Our ref: 25_33876_P

Site Location: Bridge Farm Holbeach Road
Spalding PE12 6JP

Summary of Proposal: Proposed conversion of existing barns to office use and the development of a padel club on adjacent land

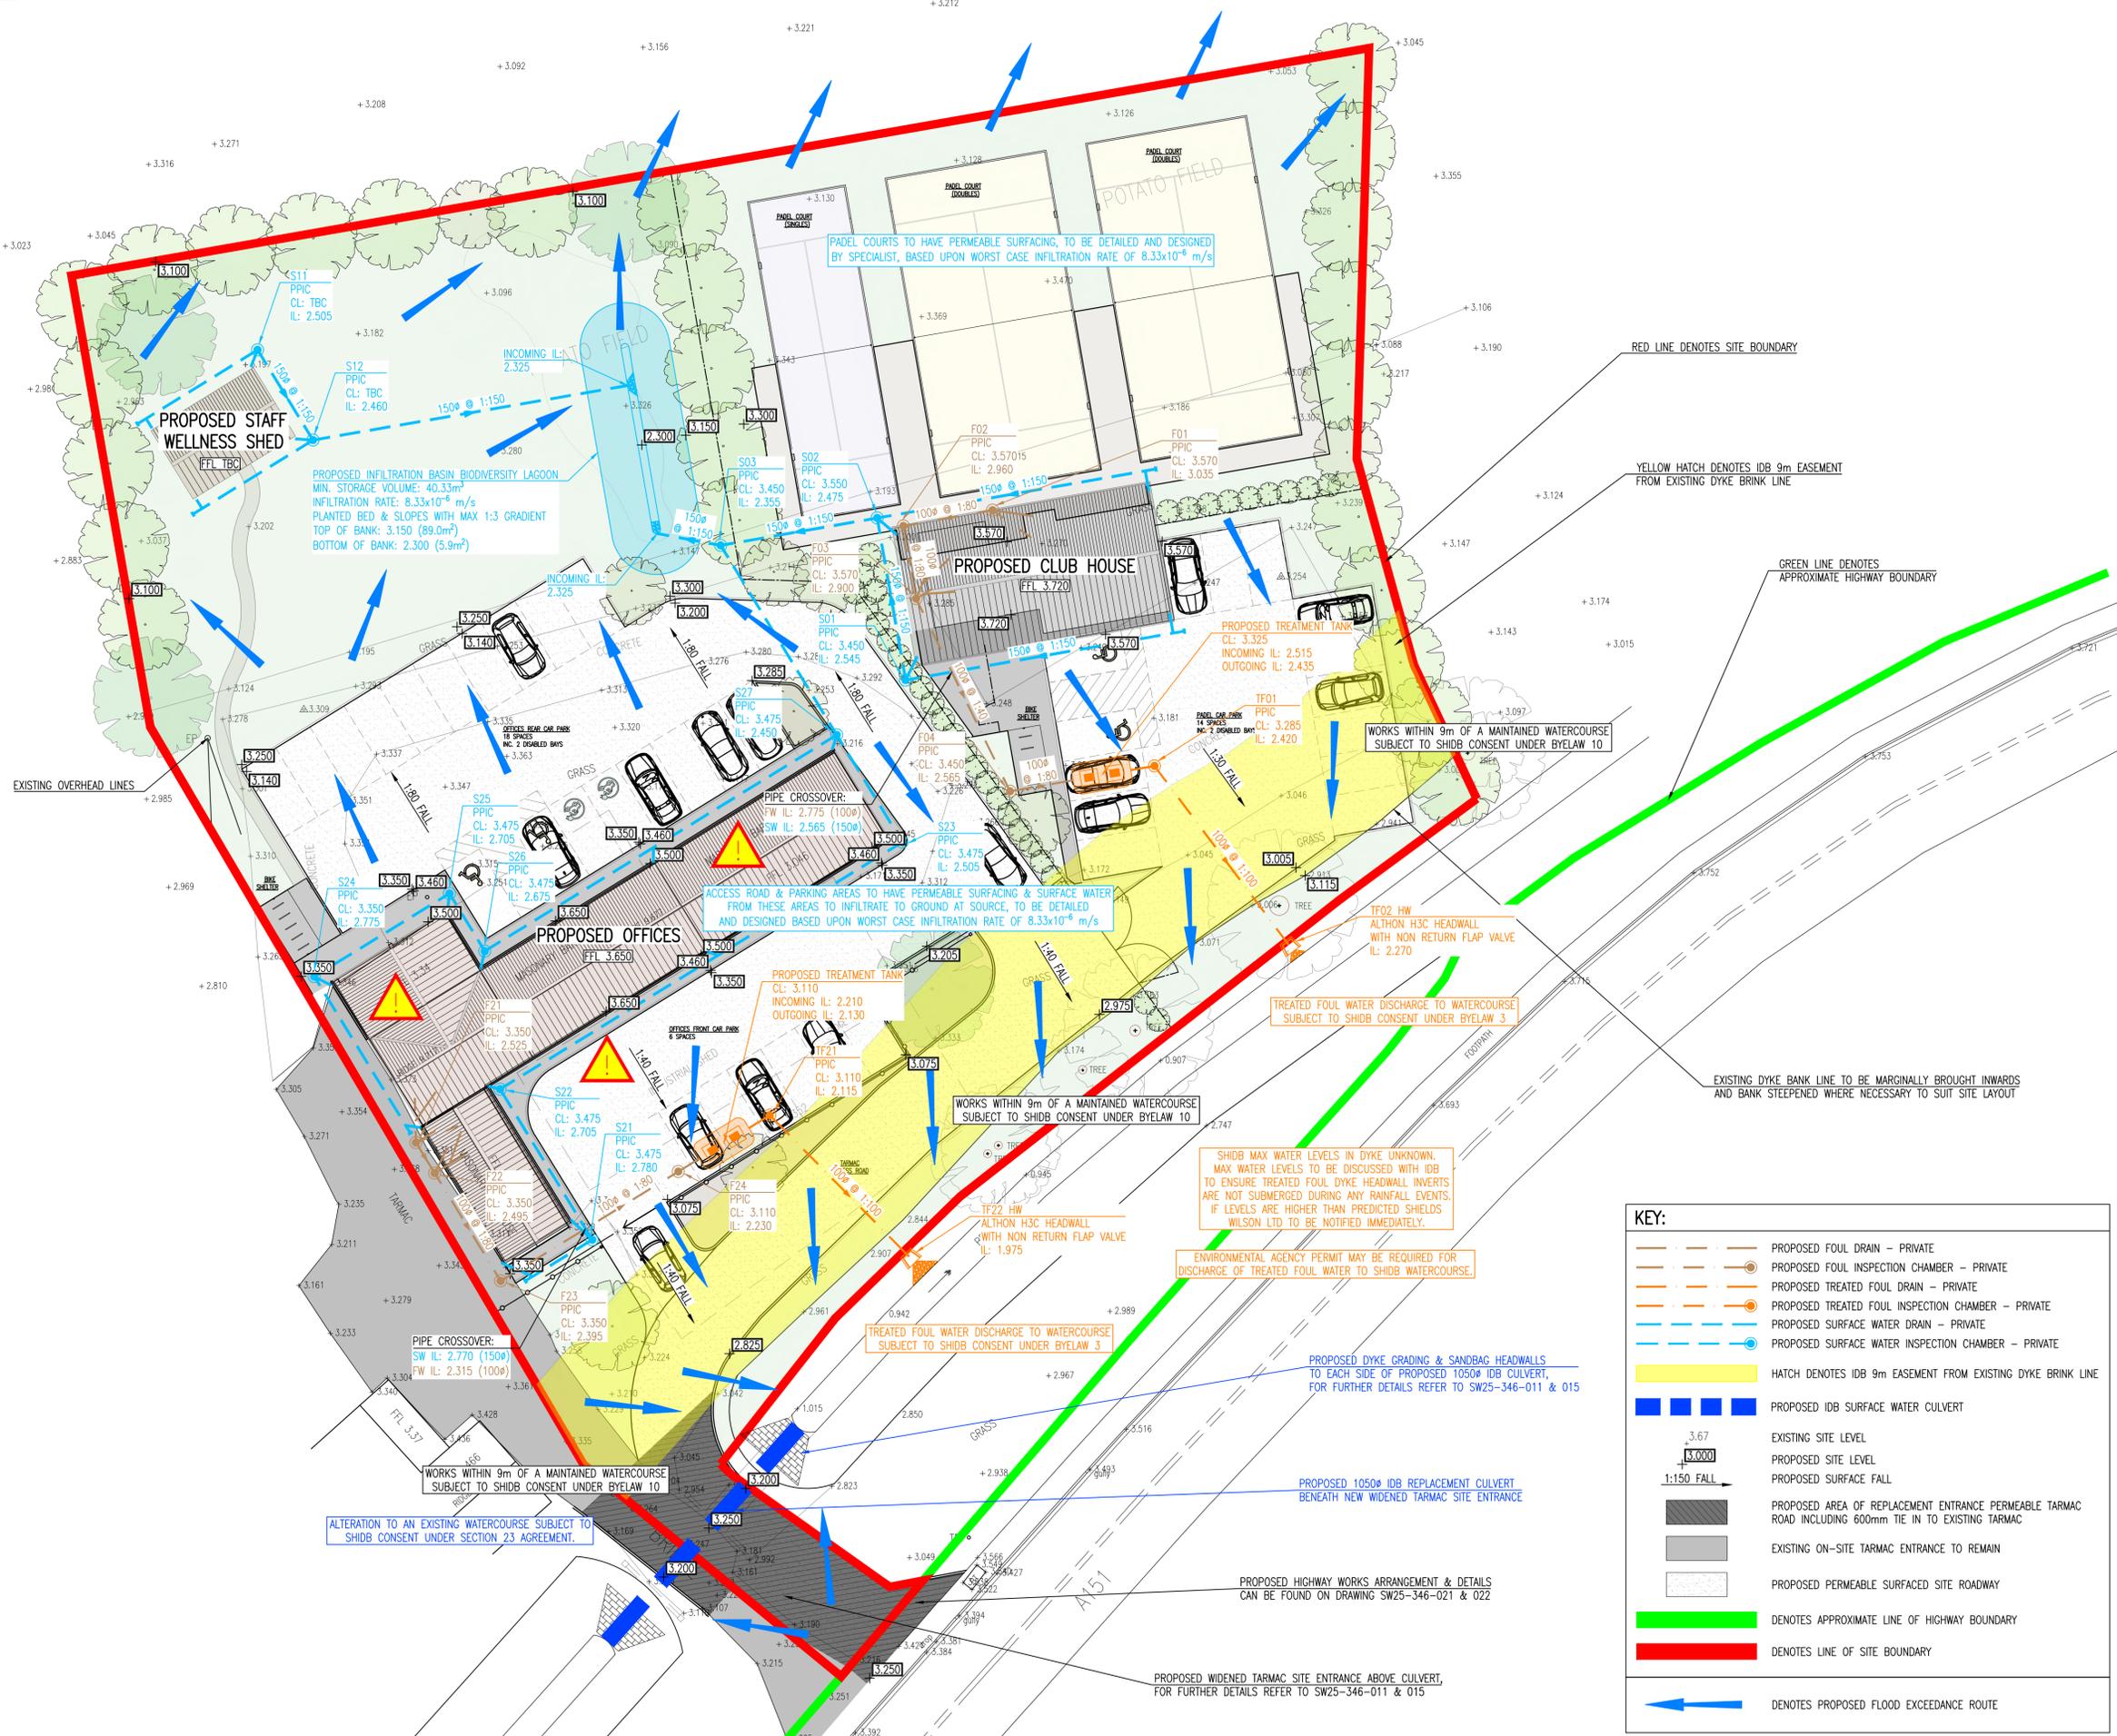
We also suggest that the agent contacts us to discuss the levels within the Boards arterial watercourse to ensure the outfalls are not submerged as suggested in the drawing titled "proposed drainage strategy and flood exceedance arrangement" (SW25-346-005 Rev A, Shields Wilson, Oct 25).

Please note that both drawings SW25-346-006 and SW25-346-005 state that a permit from the Environment Agency may be required for the treated foul water discharge to the Boards arterial watercourse, however, this is not the case and only consent from the Board is required.

The document "Proposed drainage strategy and flood exceedance arrangement" (SW25-346-005 Rev A, Shields Wilson, Oct 25), indicates the Board's 9 metre Byelaw Zone (measured from the brink of the Board's arterial watercourse) in yellow. **The Board request that no new works are installed within this 9 metre Byelaw Zone, and that it is kept clear to allow the Board to complete its statutory maintenance duties.** We would welcome a meeting with the applicant to discuss an alternative design which facilitates both the Board's requirements and the applicant's site design.

DATE	OCT. '25	SCALE @A1	DRAWING NO.	REV.
DRAWN	MRB	1:20	SW25-346-006	A

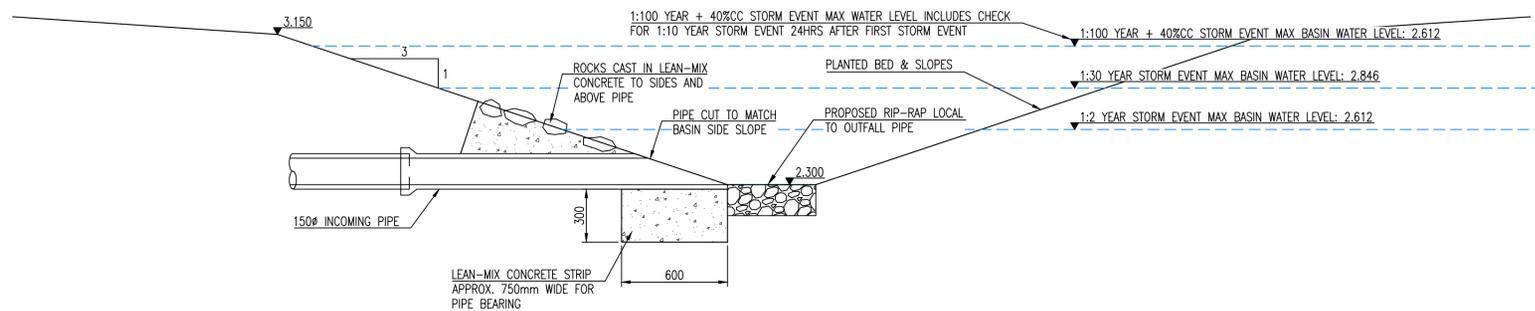
However, the Board currently objects to this proposal. The positioning of the headwalls in the drawing titled “Proposed basin & dyke drainage sections & details” (SW25-346-006, Rev A, Shields Wilson, Oct 25), suggests that the bank will be altered to fit the headwalls, **which is not acceptable to the Board.** We recommend that the headwalls are cast in-situ to prevent the need to alter the bank. Additionally, as mentioned at the beginning of this letter, we will require the applicant to enter into a legal agreement with the Board in relation to the installation of these headwalls in the Board owned watercourse. We request that the applicant contacts us to discuss this further with our Estates Officer.

**SECTION D-D  
THROUGH PROPOSED SANDBAG BRIDGE IDB CULVERT**  
SCALE 1:25

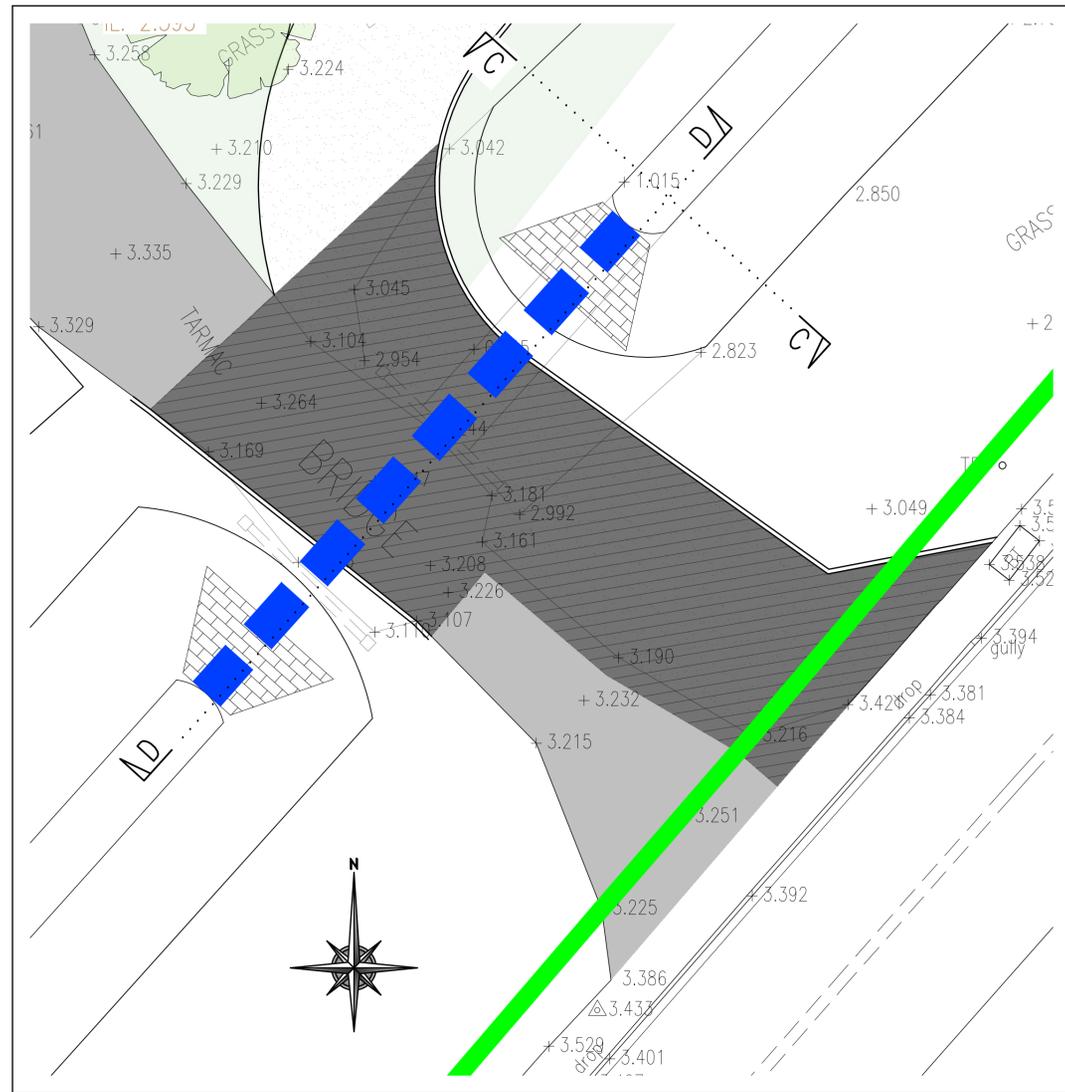
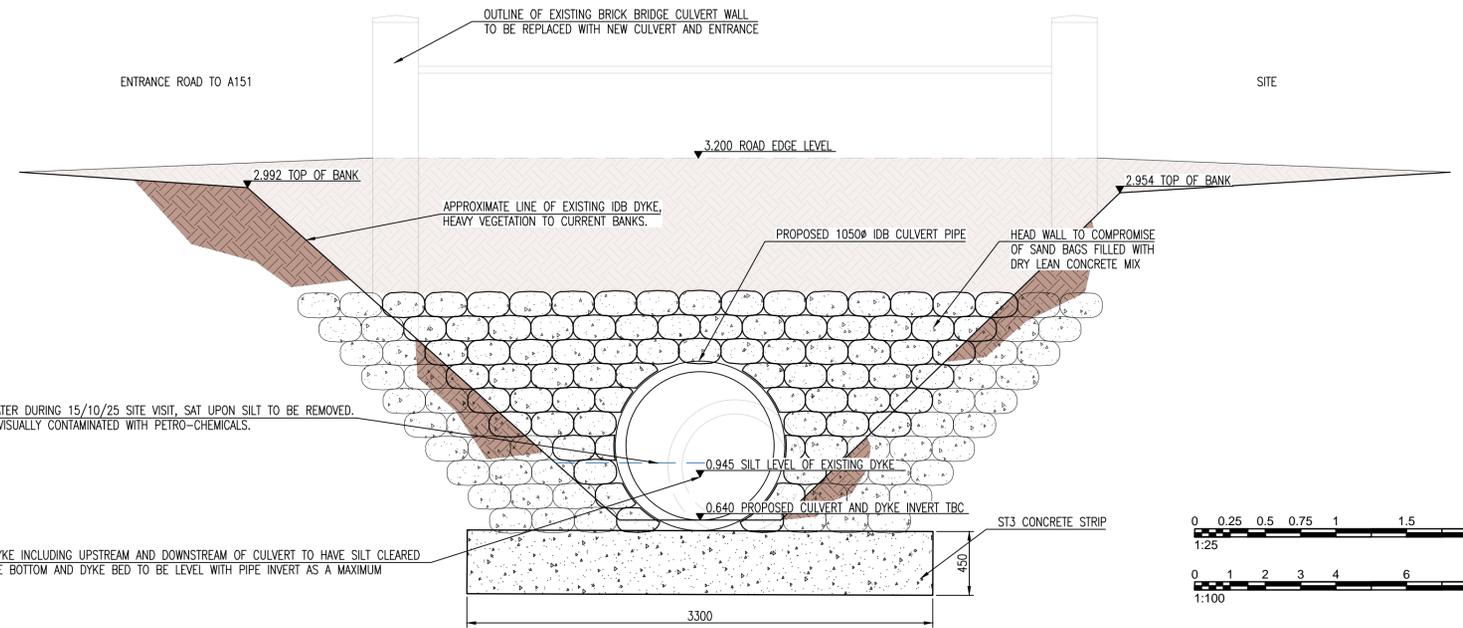
As previously mentioned, there is a Board owned arterial watercourse (known as R07 Lords (DRN208P0702)) adjacent to the southern site boundary and works are proposed to alter this watercourse including a replacement culvert, as shown in the drawing titled "Proposed padel courts and office building" (SW25-346-015, Shields Wilson, Oct 25). To enable this proposal, consent is required under Section 23 of the Land Drainage Act 1991 (and byelaw 4). As mentioned at the beginning of this letter, we require the applicant to enter into a legal agreement with the Board in relation to the proposed replacement culvert in the Board owned watercourse. We request that the applicant contacts us to discuss this further with our Estates Officer.

The Board have concerns with the current design of the culvert, including the following:

- The angle of the culvert ends do not need to be sloped. We would accept the culvert ends to have a vertical face (up to 3 bags above the crown of the pipe) and then sloped upwards. This would also provide the applicants with a wider verge and visibility splay.
- Limited details have been provided regarding the pipe material, surround and infill material of the culvert. The Board are able to provide a standard detail drawing of the information required if the applicant/agent would like to approach us to discuss this further.
- We are happy with the proposed 1050mm diameter of the replacement culvert. However, we would request that the new invert level is lowered to 0.60m O.D.N to allow for future improvements.

Appendix C – Infiltration Calculations SA01 & SA02

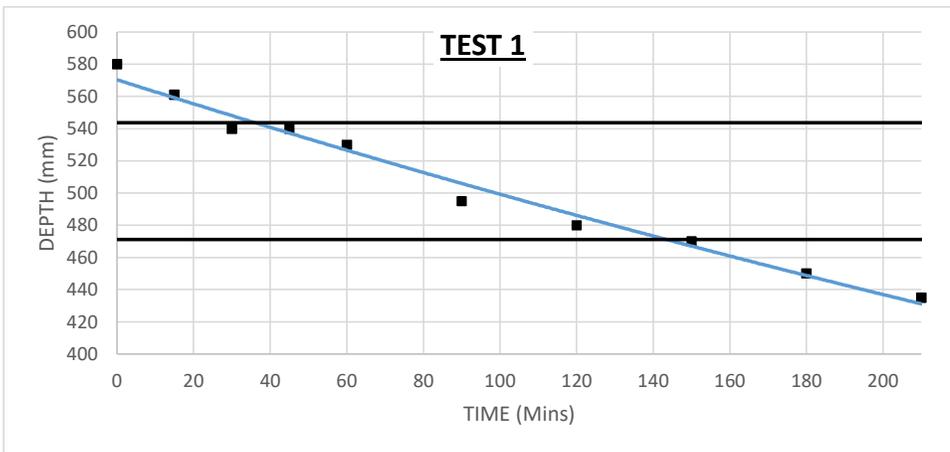
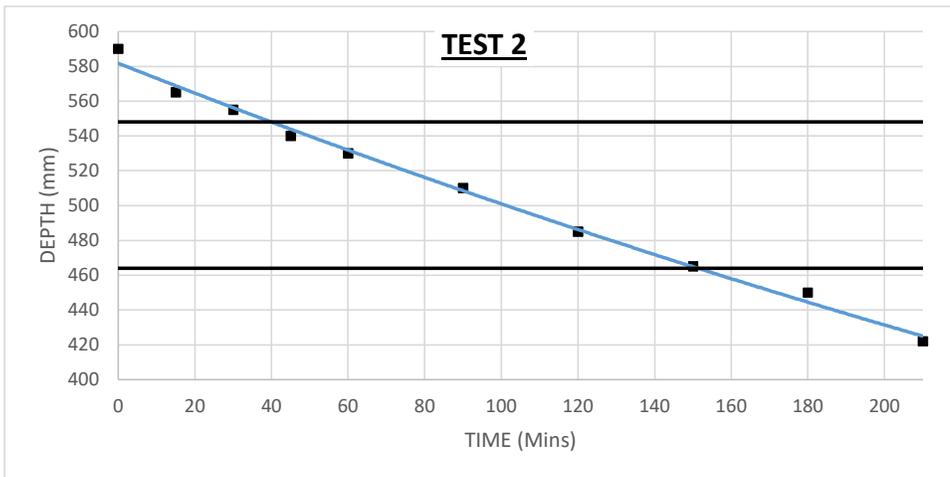
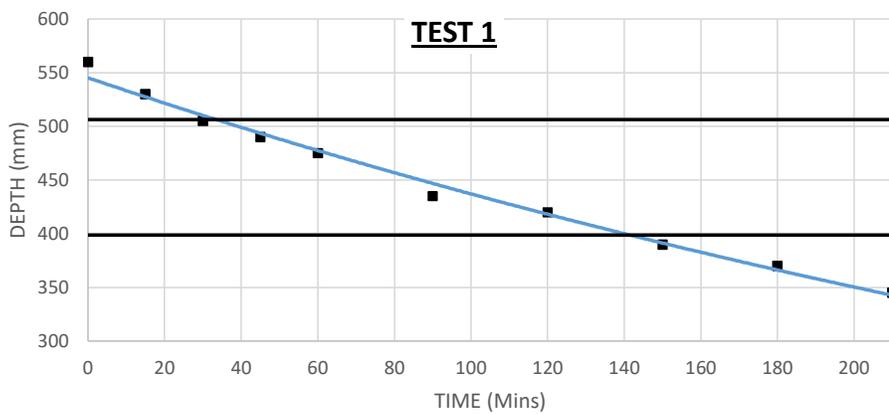
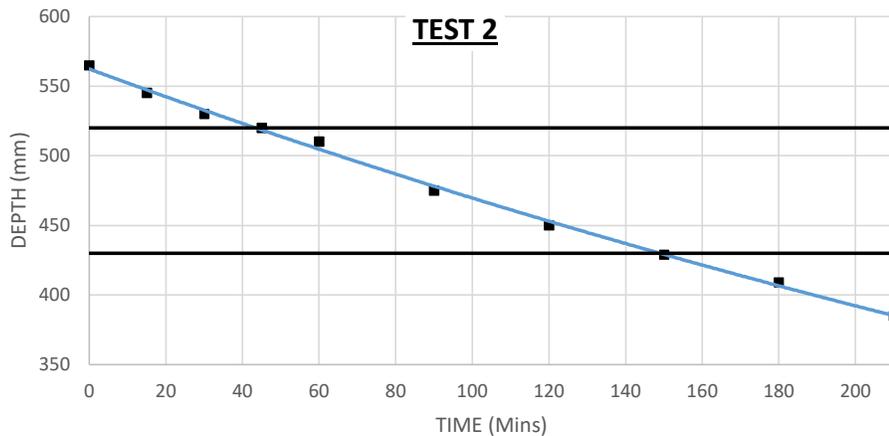
However, the infiltration calculations are not in line with BRE Digest 365, which states that a trial pit should be filled and drained three times in succession, with the slowest infiltration rate of the three tests used for design. Therefore, we recommend that further infiltration testing is carried out in line with BRE Digest 365 (or equivalent) to determine the efficiency of infiltration at this site.
